URBAN DESIGN LANDSCAPE COMMENTS

Site Address: **BROADWATER LAKE, MOORHALL ROAD, HAREFIELD**

Planning ref: **2382/APP/2023/2906**

Proposal: Redevelopment of the site to create the Hillingdon Watersports Facility and Activity Centre including demolition of existing Broadwater Lake Sailing Club (BSC) clubhouse at the north of the lake and erection of a building including changing facilities, meeting rooms, storage, Workshop and seasonal worker accommodation (sui generis), activity shelters; installation of pontoons and slipways; boat shed; equipment storage huts; boat parking and racking areas; camping area; outdoor activity areas; ecological enhancement throughout the site; new pedestrian routes through the peninsula; landscaping including new woodland, dense vegetation screens and boundary treatment; access road; localised dredging and land reclamation; relocation of existing sailing area and creation of floating reedbeds within the lake; coach drop off and turning area; vehicle parking; cycle parking; and associated works. (Re-consultation following submission of amended plans and documents)

Drawing Title:
Safety Zone - Proposed Elevations

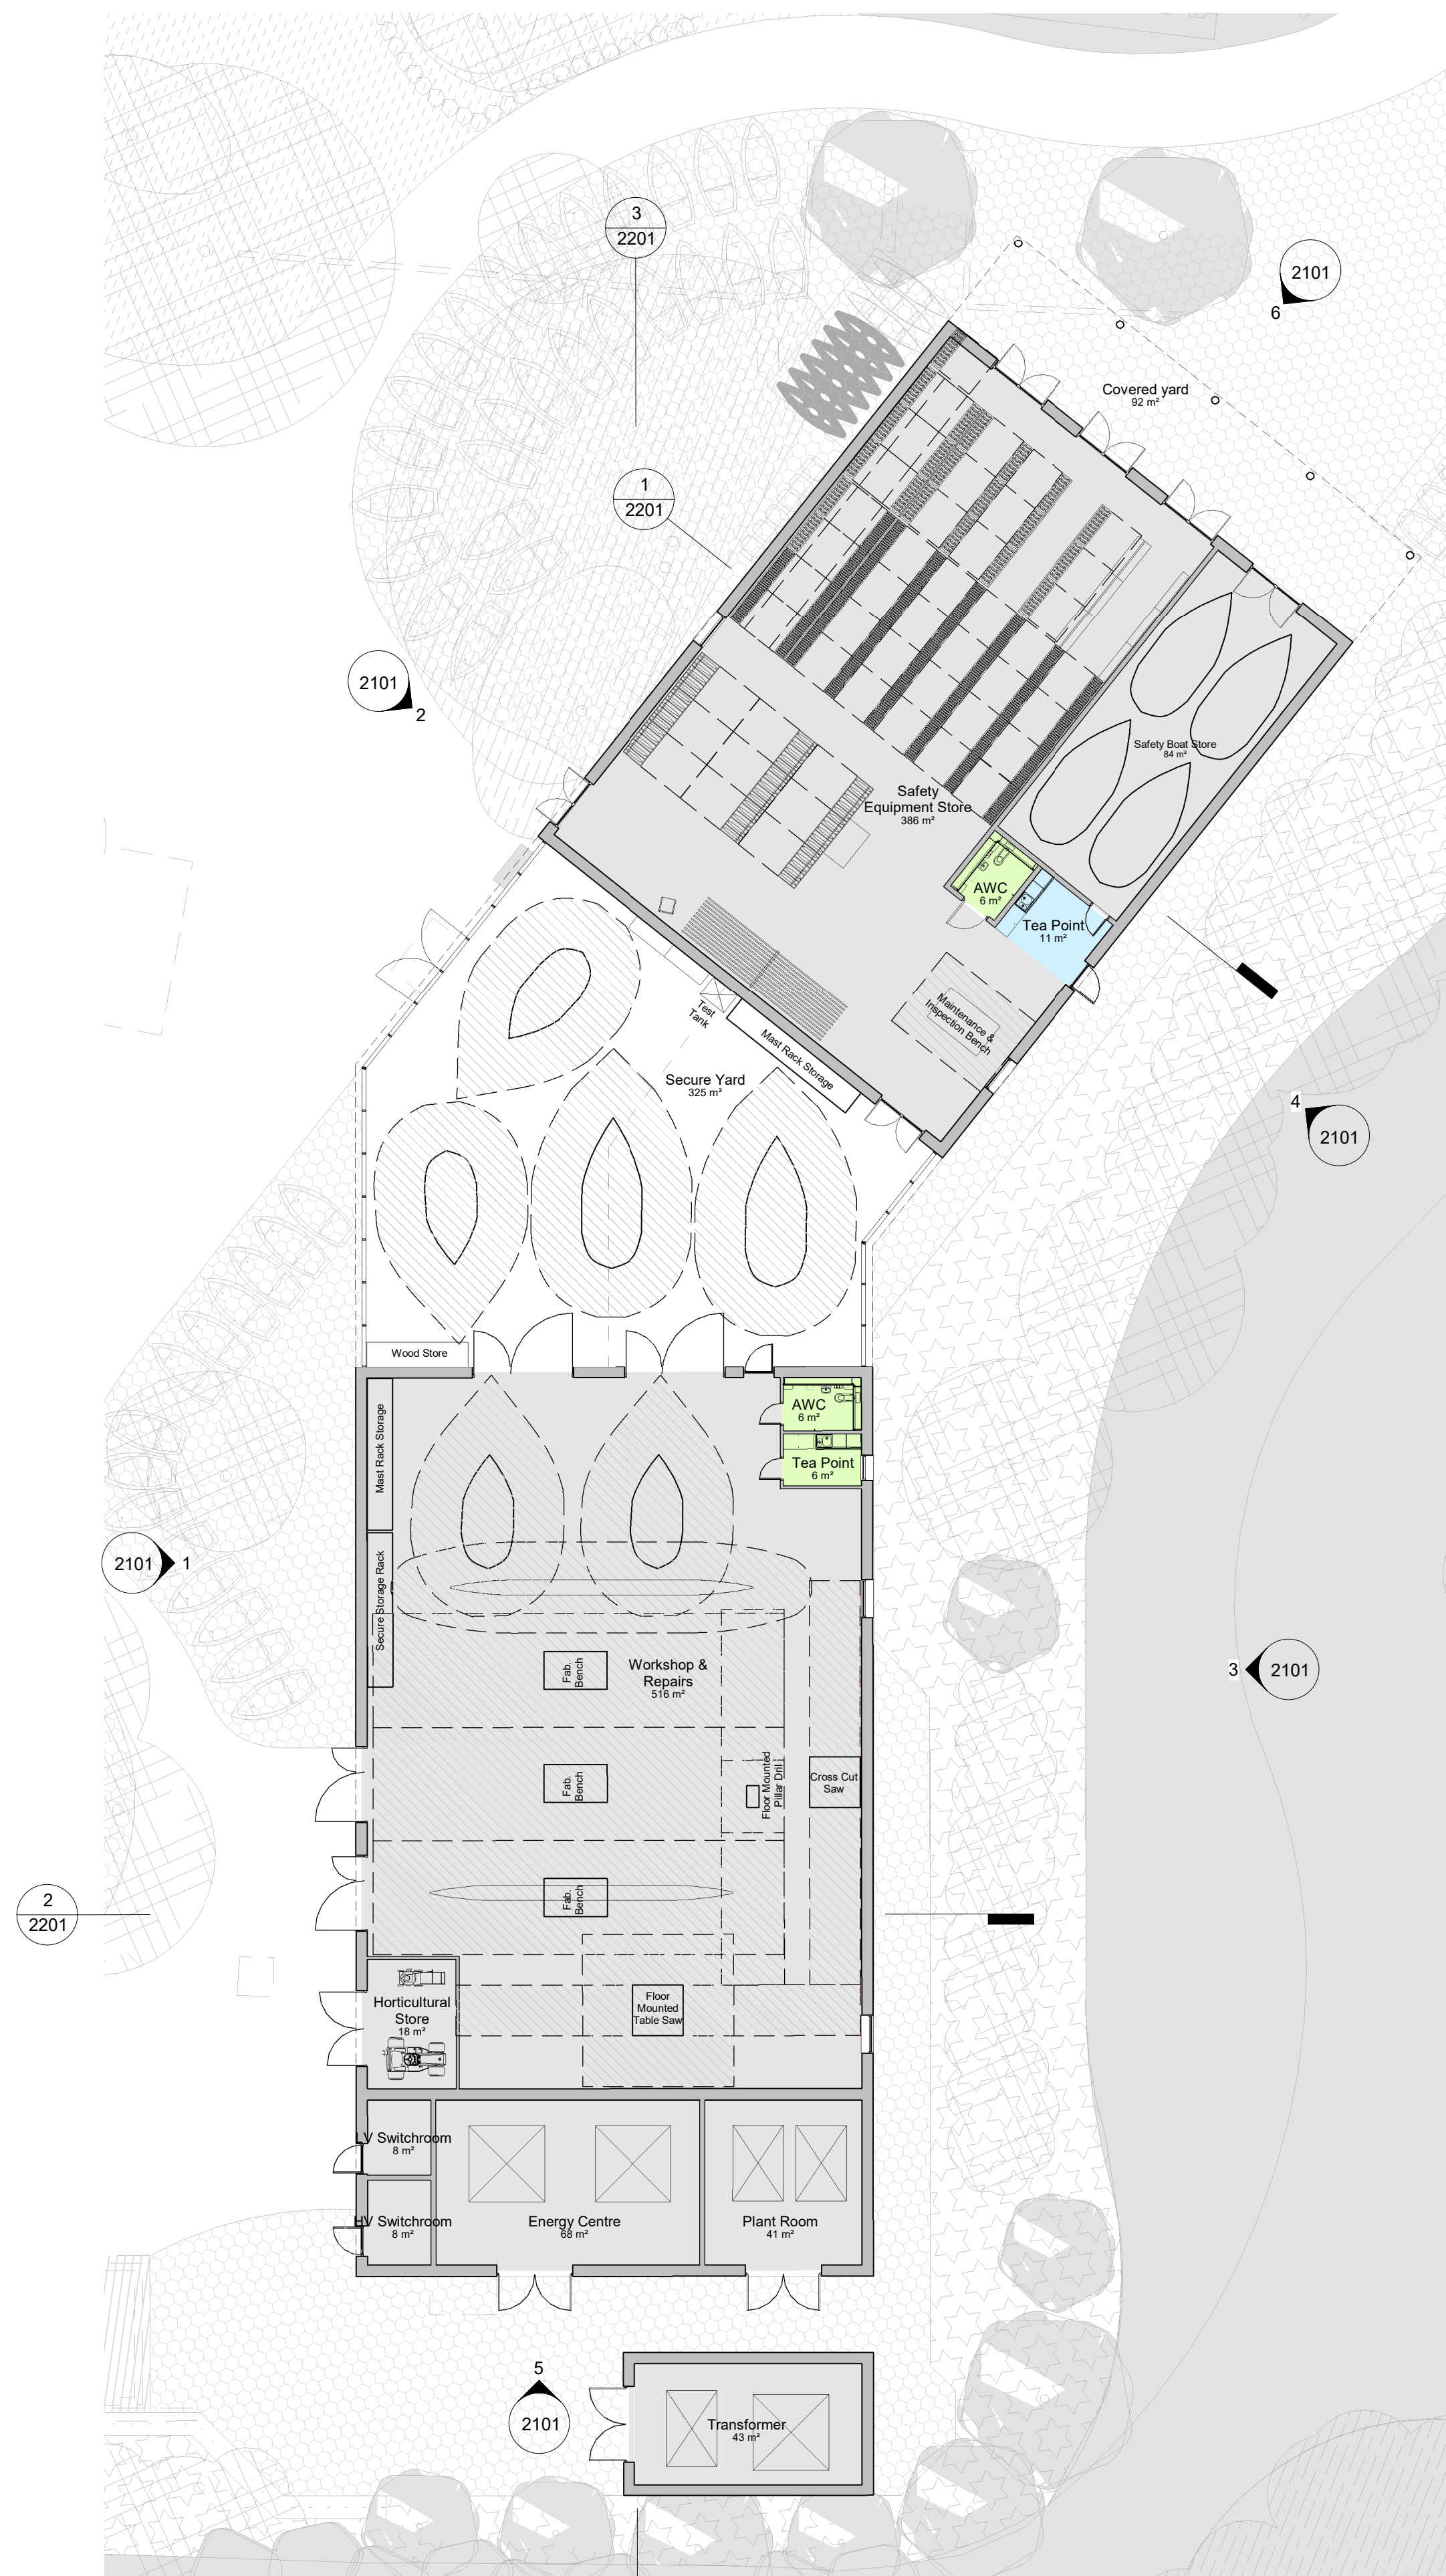
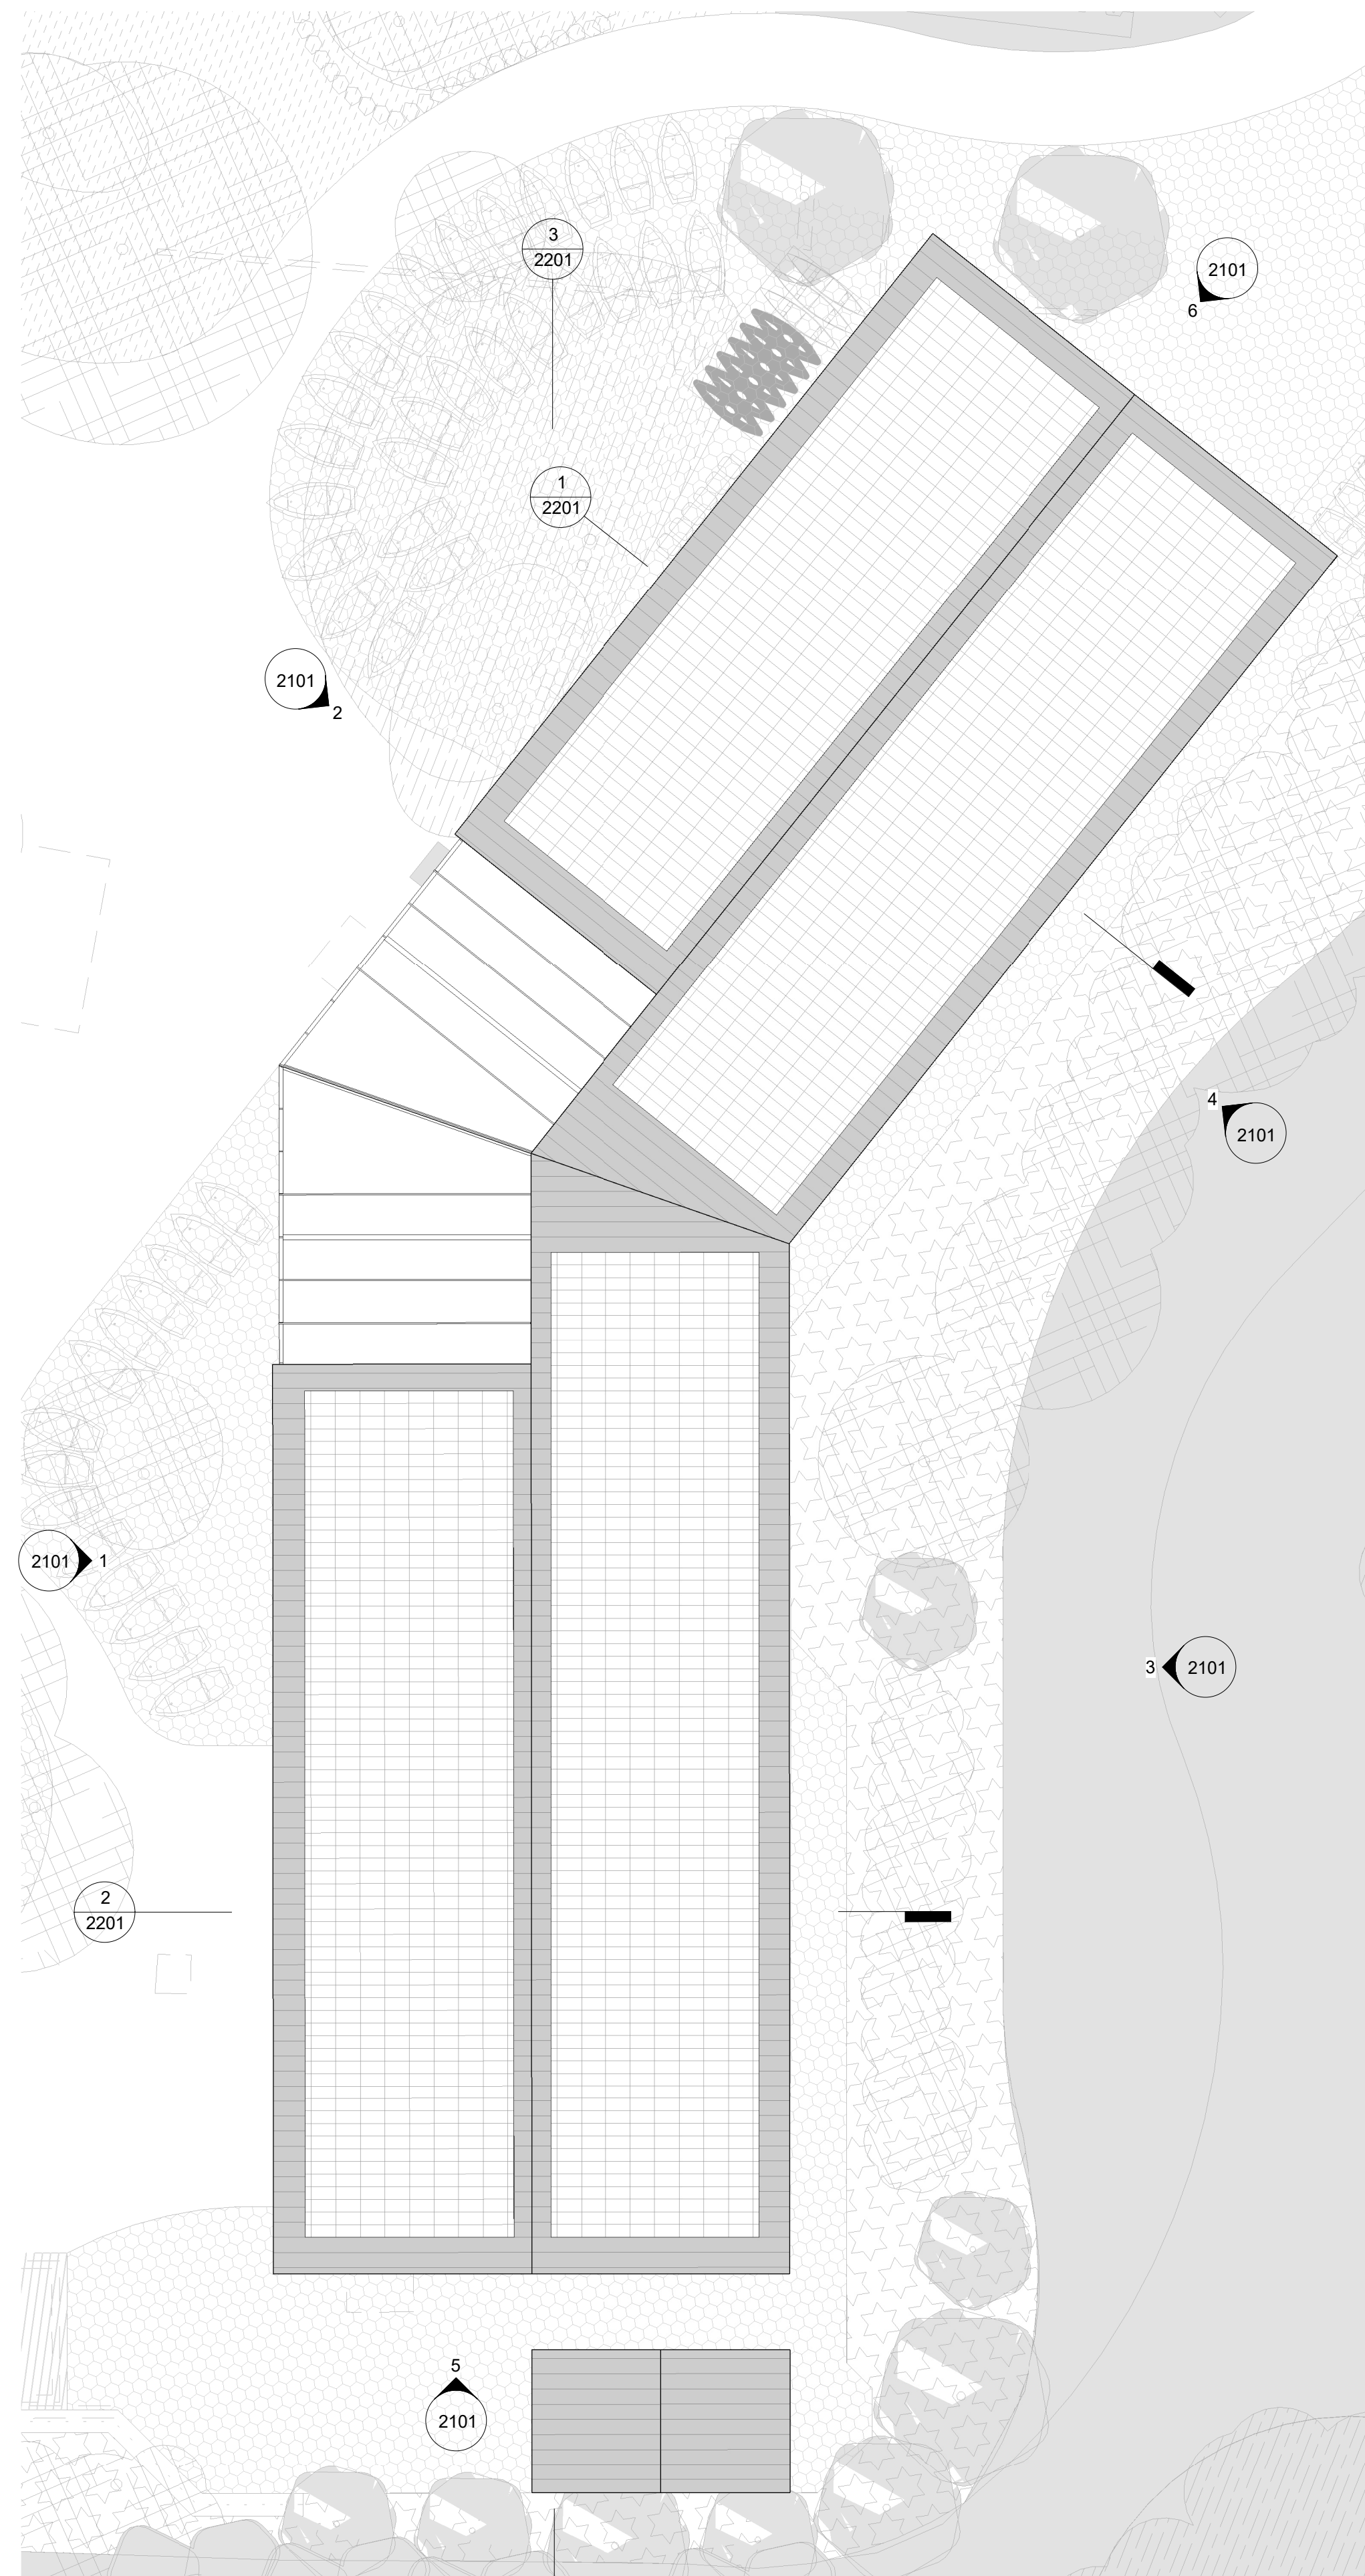
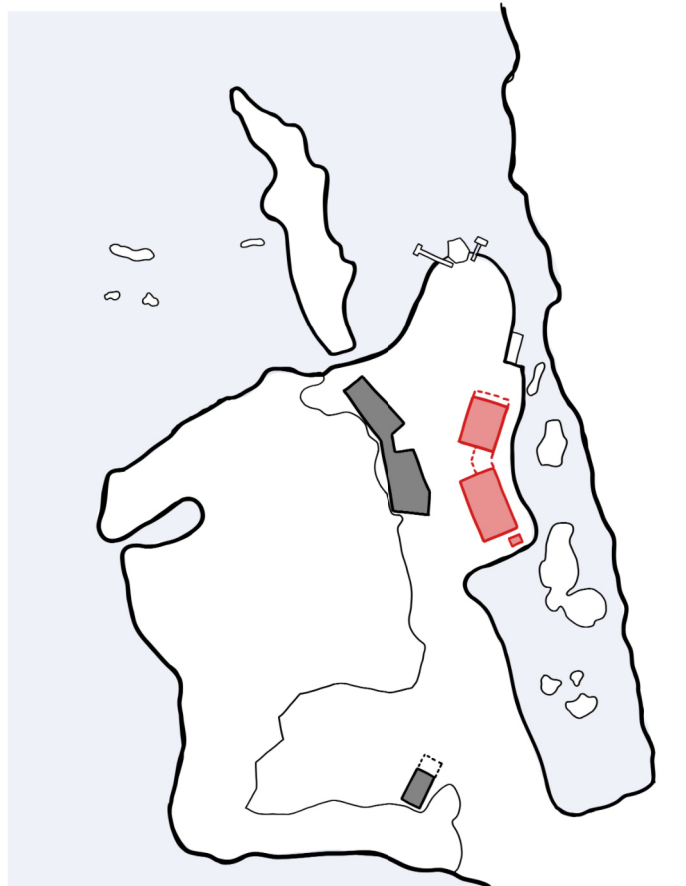
The safety buildings should create the second of a pair of buildings that appear similar in materiality and design. The flint and standing seam roof follow this design intent. However concern is raised that the PVs are shown on the most visible west elevation.

Further the exposed structure appears awkward adjacent to the solidity of the flint. More explanation is required for this element, to explain the roof material and structure material.

Further details will be required at the next stage of design development to clarify the window framing and materials of the window frames. Traditionally, flint buildings incorporated substantial, robust framing around windows to accommodate the construction methods used for flint walling.

4 Camp Zone - Section AA

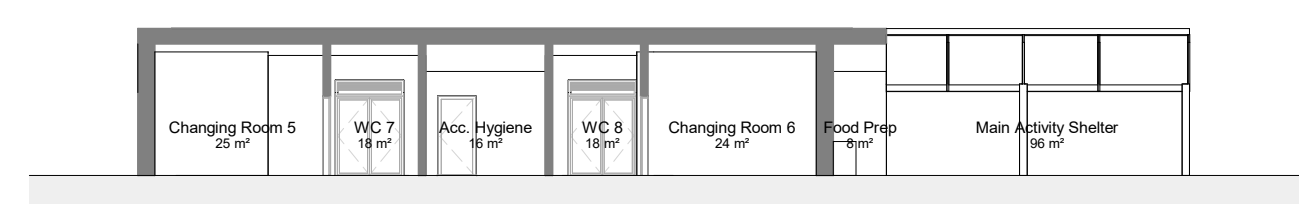
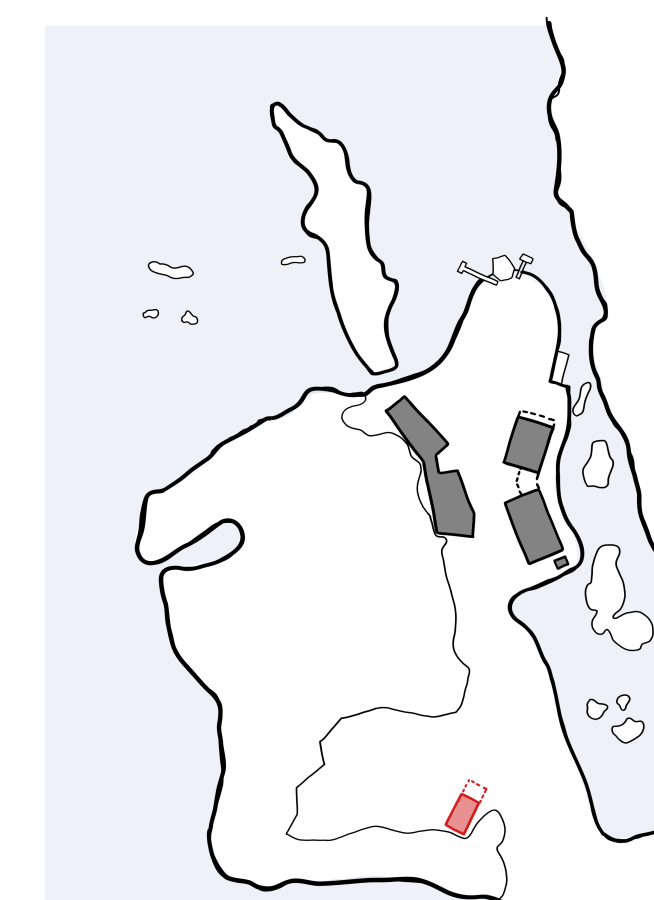
- There remains a concern that the Camping Zone building is excessively large, with a covered roof area that would be better served by a seasonal covering, such as awnings. This approach would reduce the building's footprint and massing, and would also help prevent birds from nesting in the roof rafters, which could render the building unusable. Additionally, to better integrate the structure with its surroundings and further minimise its mass, a flat green roof would be a more suitable option.
